Your ref: SSD-11606719
File no: MC-20-00011

SSD-11606719 – Eastern Creek Recycling Ecology Park Throughput Increase

Blacktown Council's submission to SSD-11606719 – Eastern Creek Recycling Ecology Park Throughput Increase

RETAINING WALL PLAN RW03

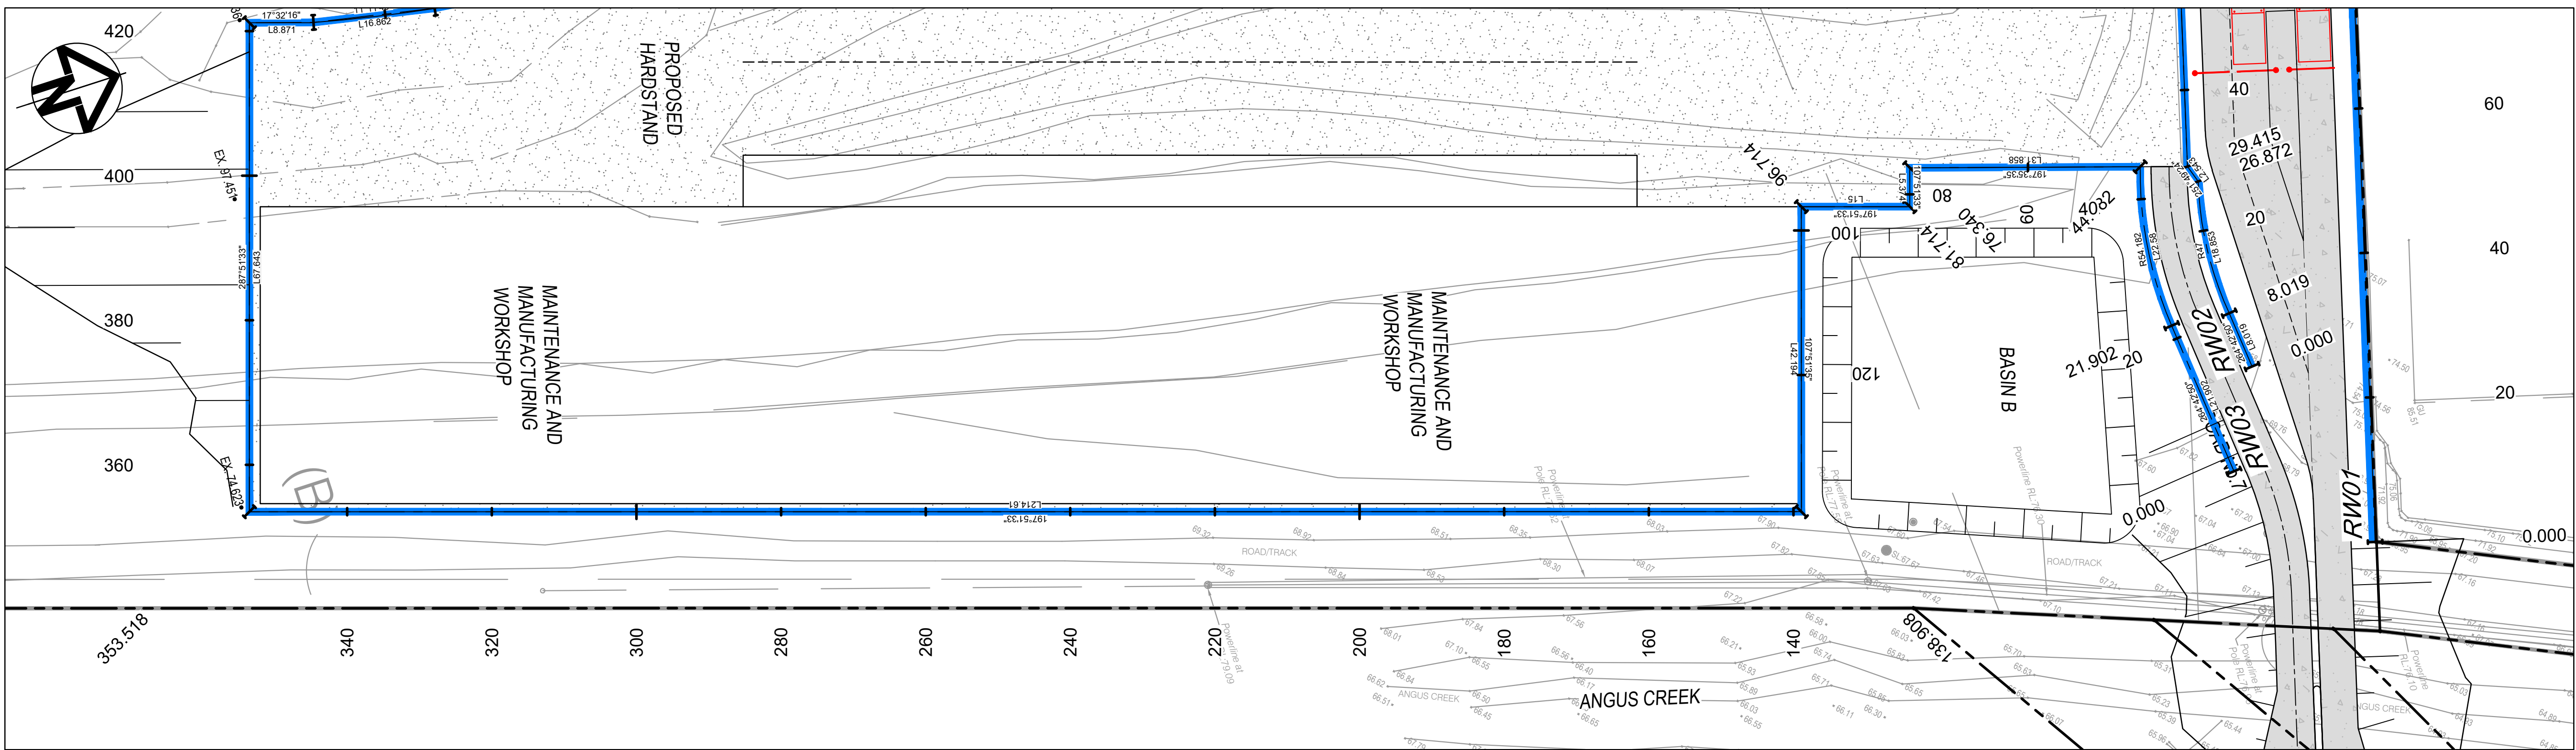
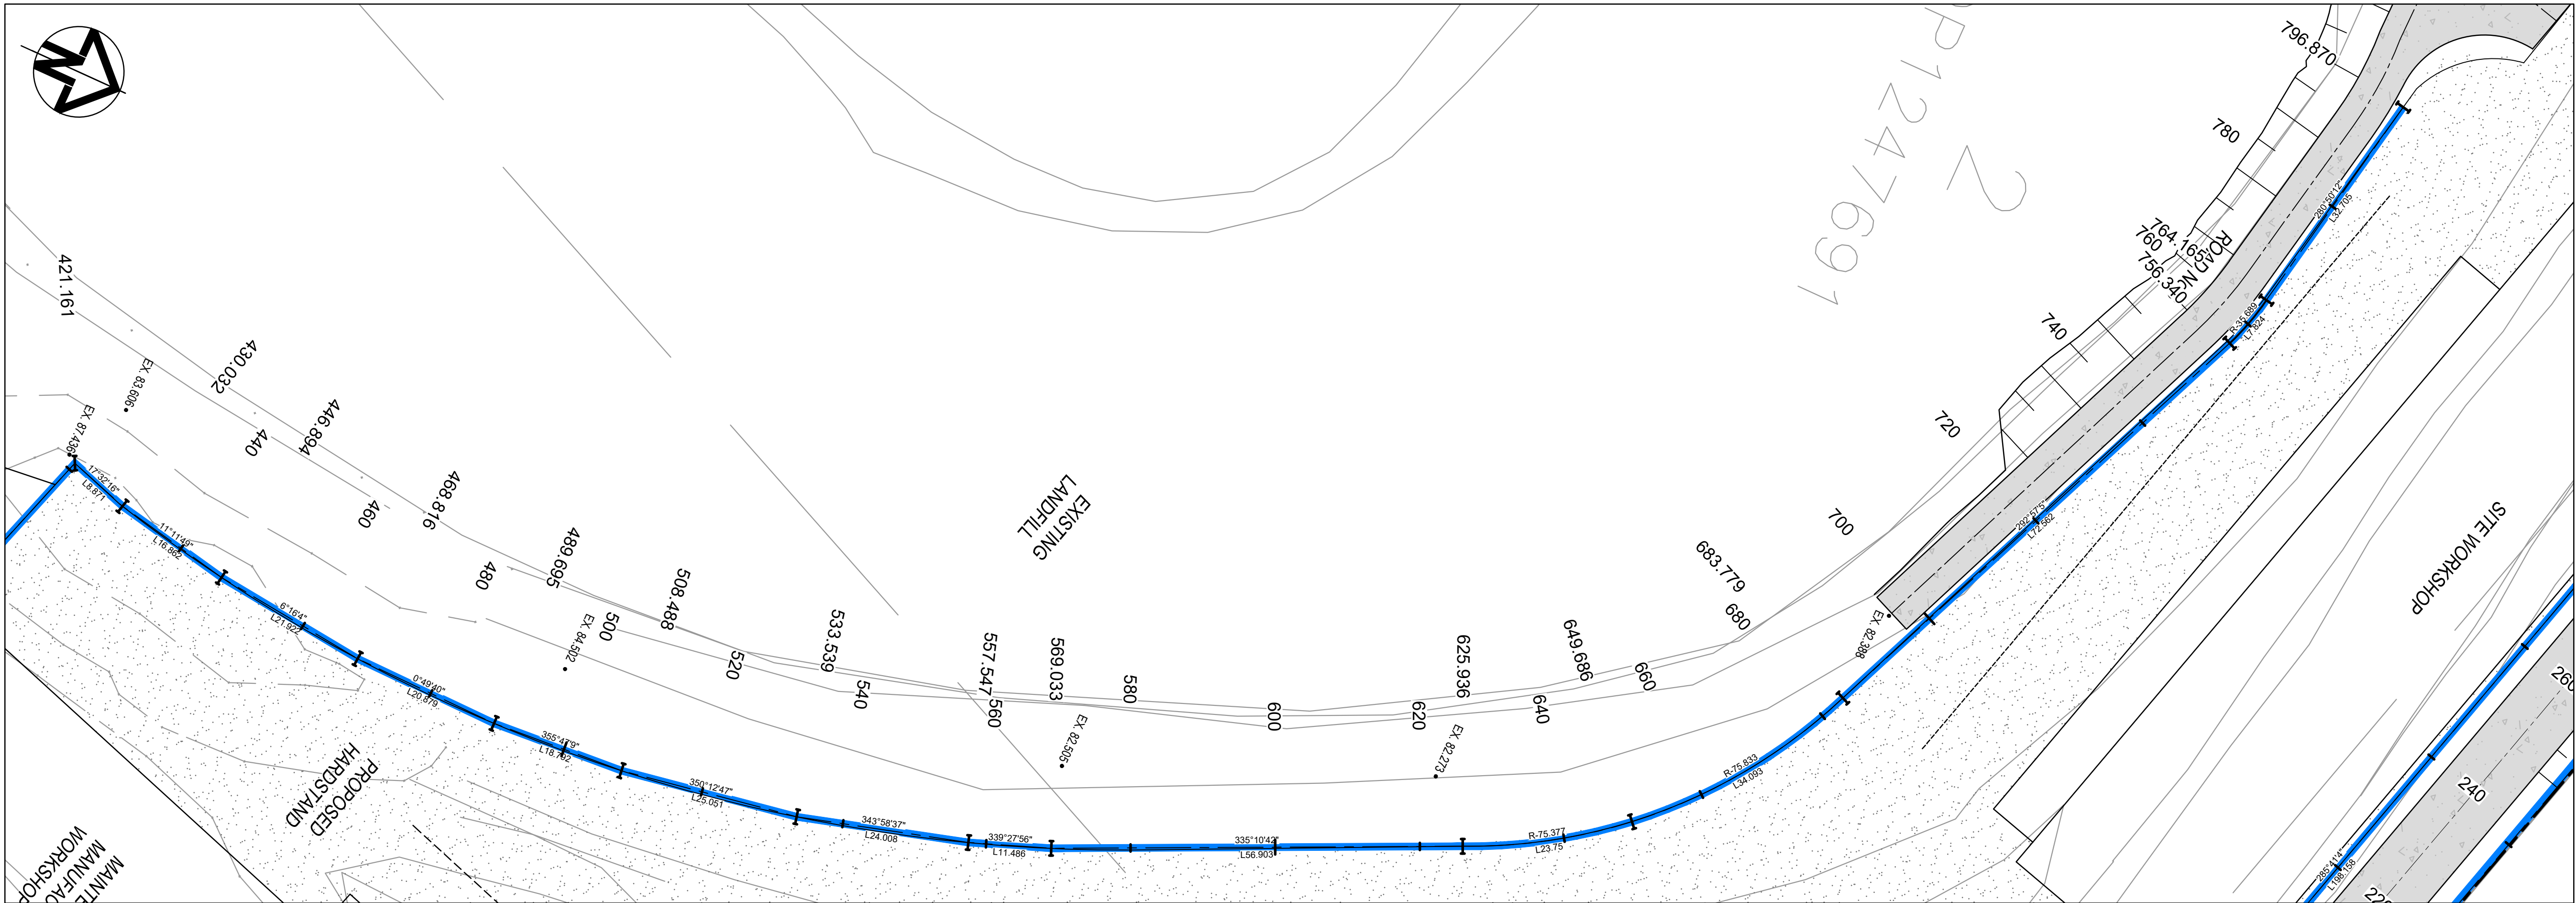
- j. The retaining wall details for the proposed 10.5m high retaining wall 3 that runs parallel to Kangaroo Avenue, is to be amended to show terracing of the retaining wall to allow for a ratio of 3m in height to 1.5m in width for the stepping. The amended plan is to show how the 1.5m terraced stepped area will be suitably landscaped to provide a green wall and to screen the height of the retaining walls from Kangaroo Avenue.
